Recommendation Report for Planning Permission for Works or Extension to a Dwelling

REF NO: A/112/26/HH

LOCATION: 12 Lansdowne Way
Angmering
BN16 4LB

PROPOSAL: Hip to gable loft extension, change of the workshop door to a window, internal alterations and associated works

Loft Extension
Elevations as proposed

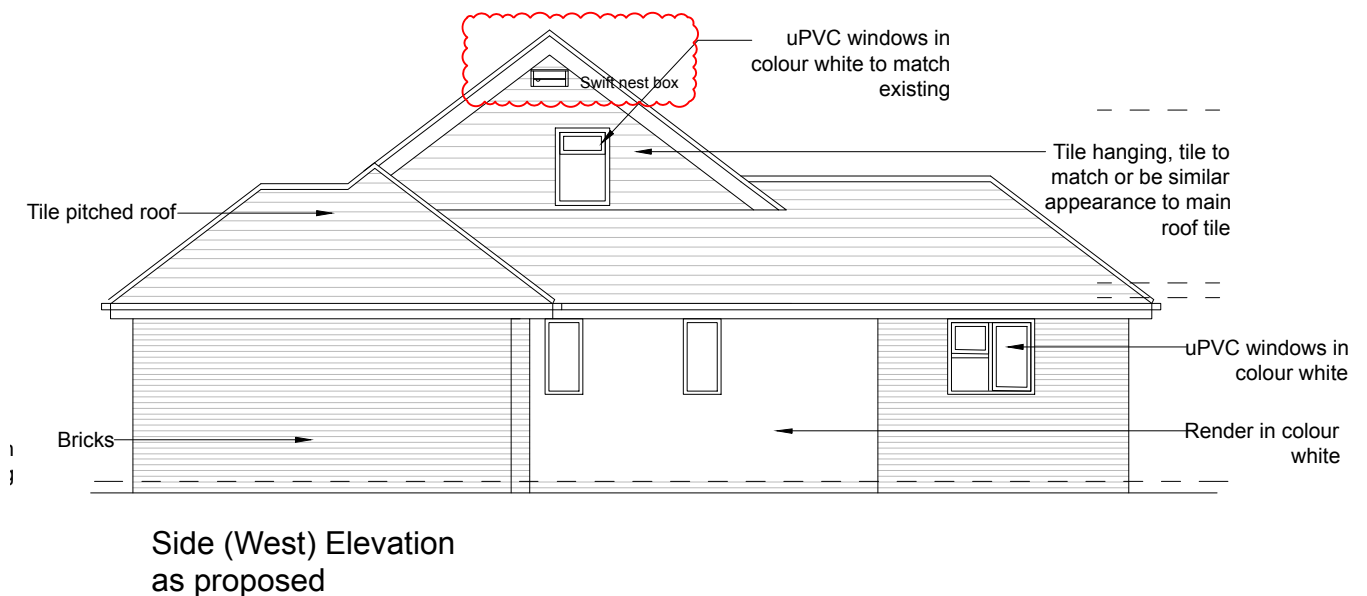
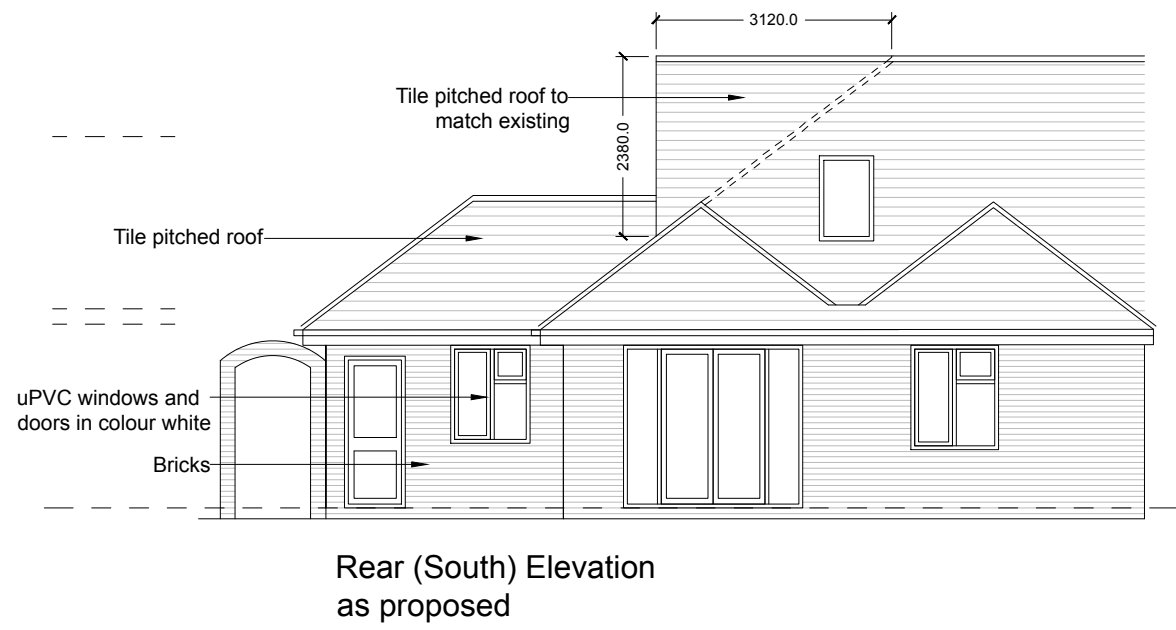
The proposal would construct a hip-to-gable roof extension, forming a gable end on the western flank elevation. The maximum ridge height would remain unchanged at approximately 6.1m. The hip-to-gable extension would increase the ridge width by approximately 3.1m to 6.4m and would be visible within the street scene, similar to the gable-end roof forms at Nos. 30 and 35 Lansdowne Road. It is noted that the roof could be altered in a similar way under permitted development.

On the front northern elevation, the existing garage door on the western flank would replace with a window finished to match the existing dwelling.

The proposed hip-to-gable roof extension would be finished with tile hanging on the gable wall and tiles to match the existing pitched roof. The front northern elevation fenestration and brickwork would also match the existing host dwelling. The use of matching materials would ensure that the proposal integrates cohesively with the host dwelling and is therefore in accordance with ALP policies D DM1 and D DM4 and policy HD4 of the ANP.

The proposal would include the insertion of a window to replace the garage door on the western flank of the front elevation. This would have an outlook of their front amenity. Given that the separation distance would be maintained between the window and the neighbouring properties to the north, the proposed fenestration would not result in unacceptable overlooking or loss in privacy to the neighbouring dwellings.
